## KITTITAS COUNTY DEPARTMENT OF PUBLIC WORKS

**FROM:** Mark R. Cook, Director

**RE:** Hyak PUD Final Development Plan

HYAK SNOW STORAGE EXHIBIT

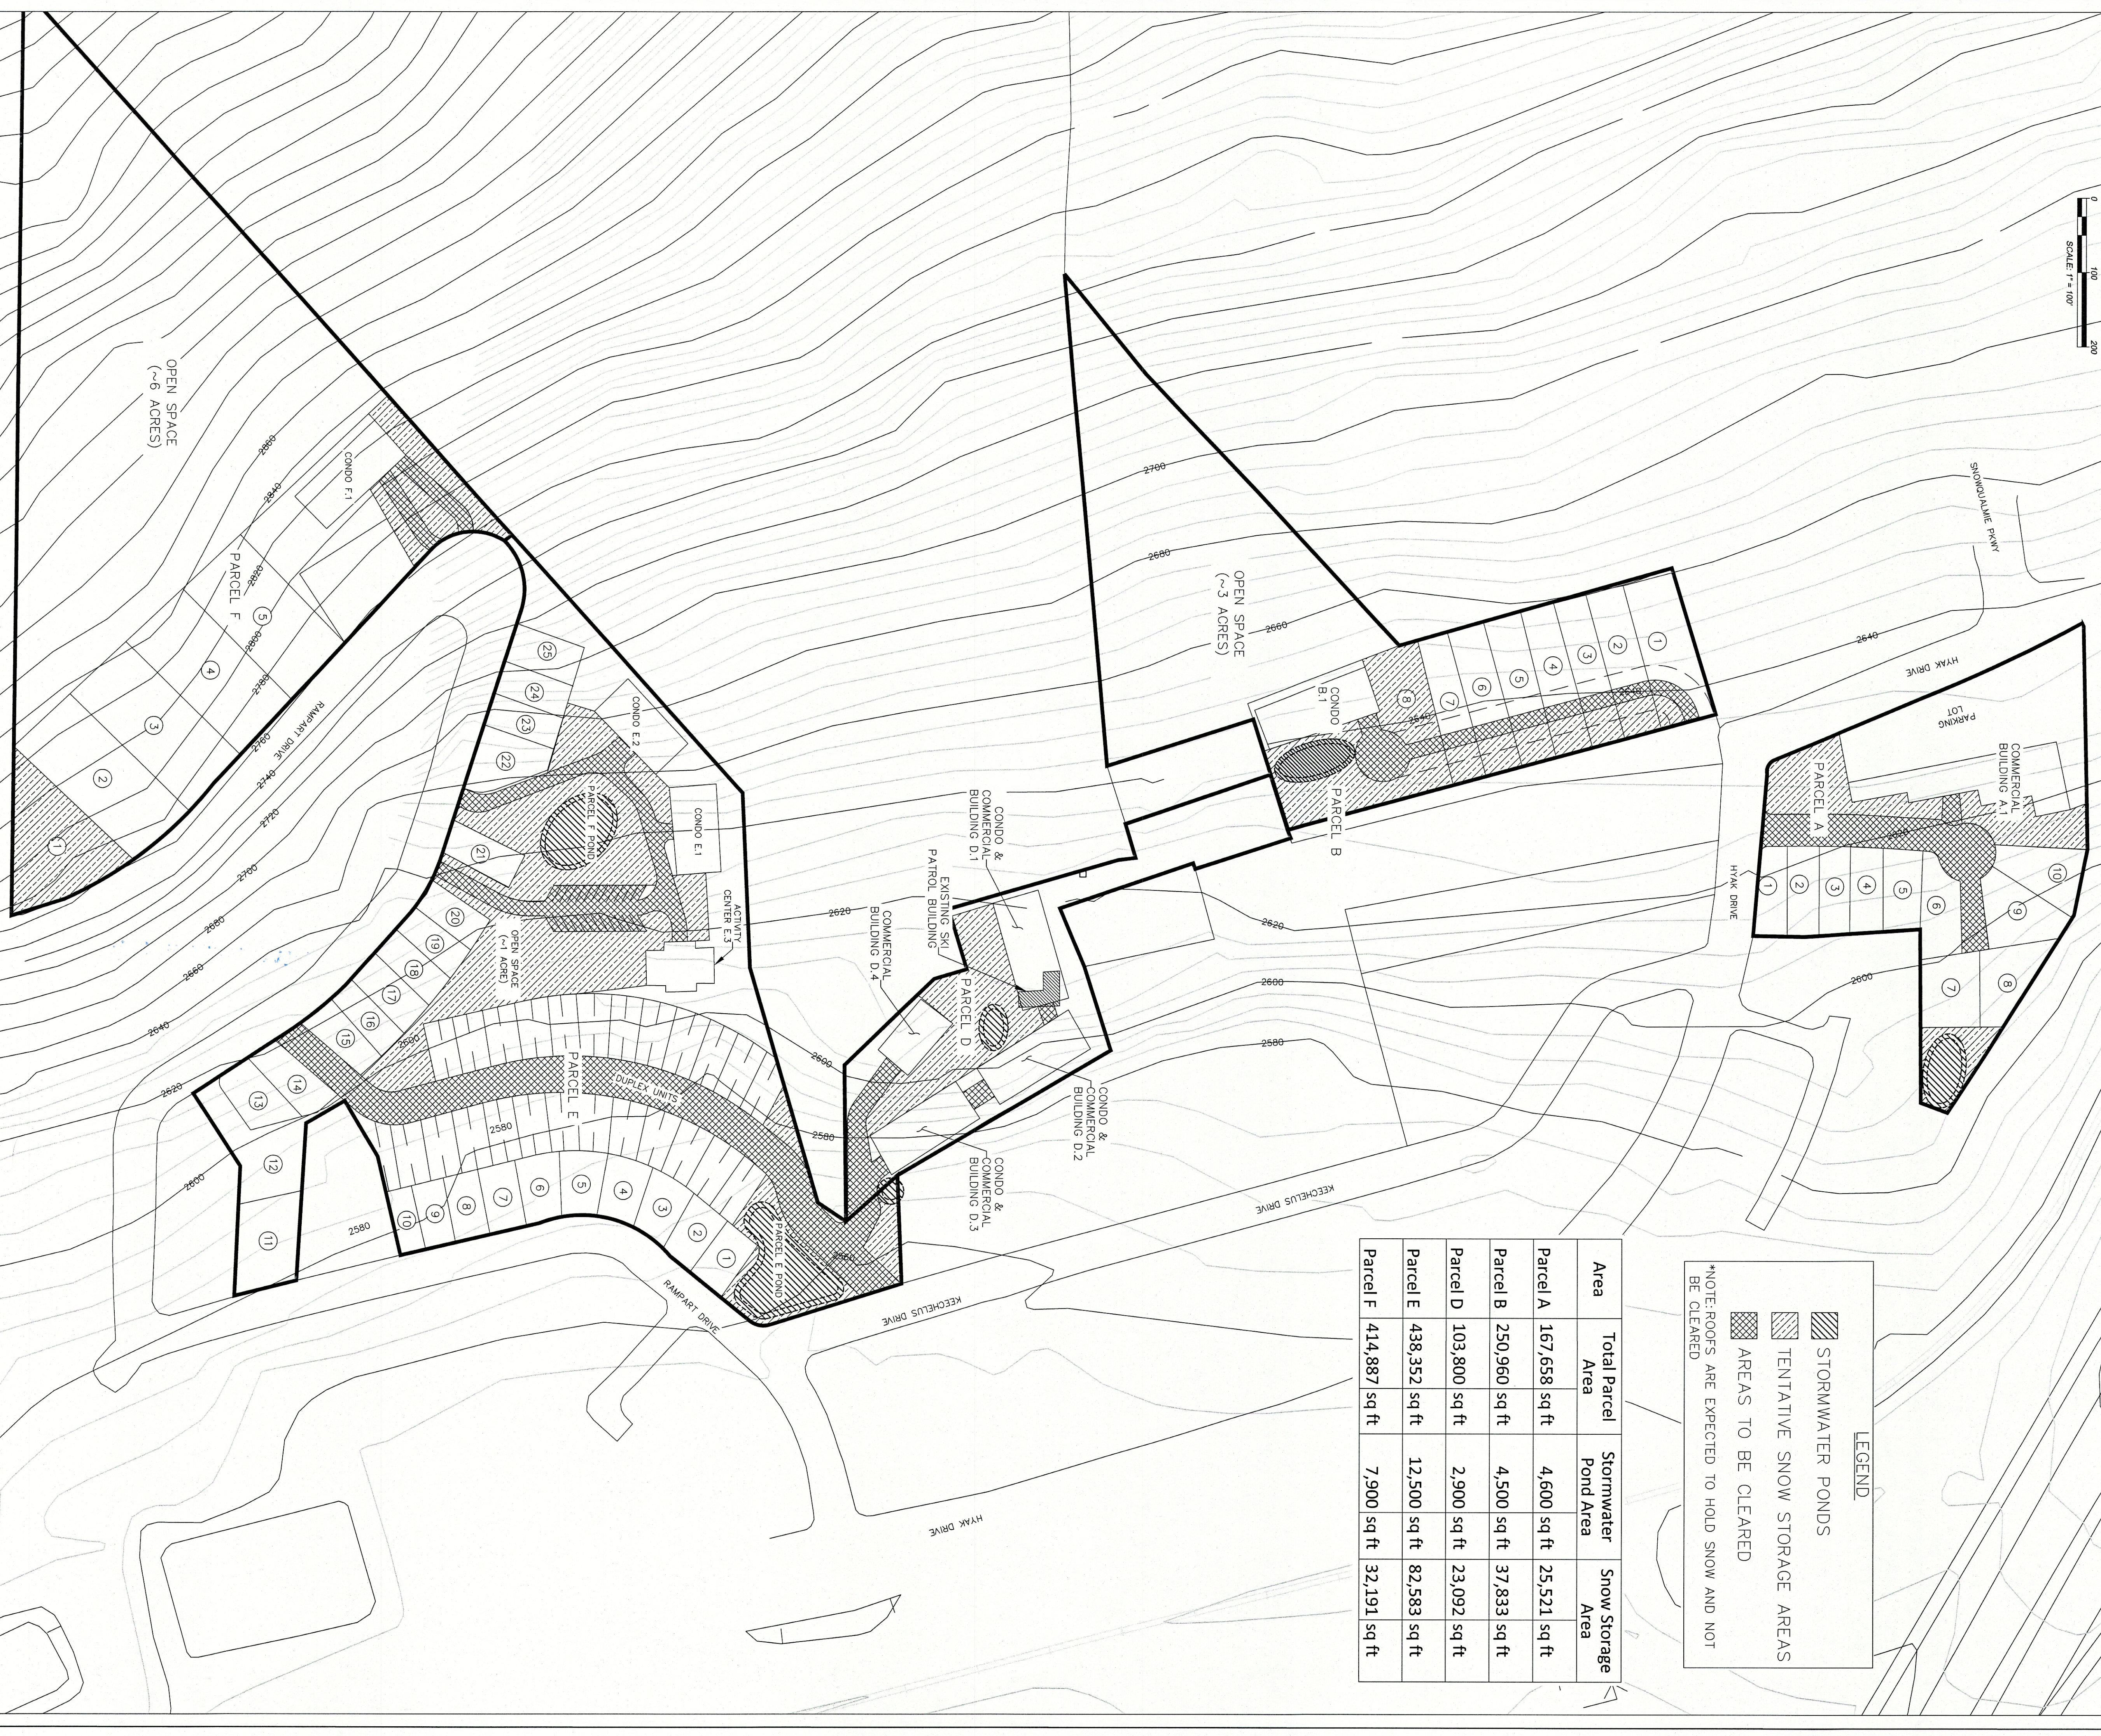
1. Public Works is experiencing increasing inability to remove snow within the Hyak Community. The issue is development of vacant parcels eliminating the ability to target our snow blowers. The proposed development will exacerbate this condition. It is likely that at some point in the near future, property owners in Hyak will be required to participate in mandatory Road Improvement District (RID) addressing increasing maintenance costs associated with snow removal. The exact specifics of snow removal and storage will be addressed during final plat submittal.

6. Proposing snow storage in stormwater ponds is problematic given that the facilities will likely be much smaller in final design than the conceptual plan as provided. Presuming snow storage in stormwater ponds is possible, spring runoff will likely result in area flooding as the ponds will not be available for snow runoff water.
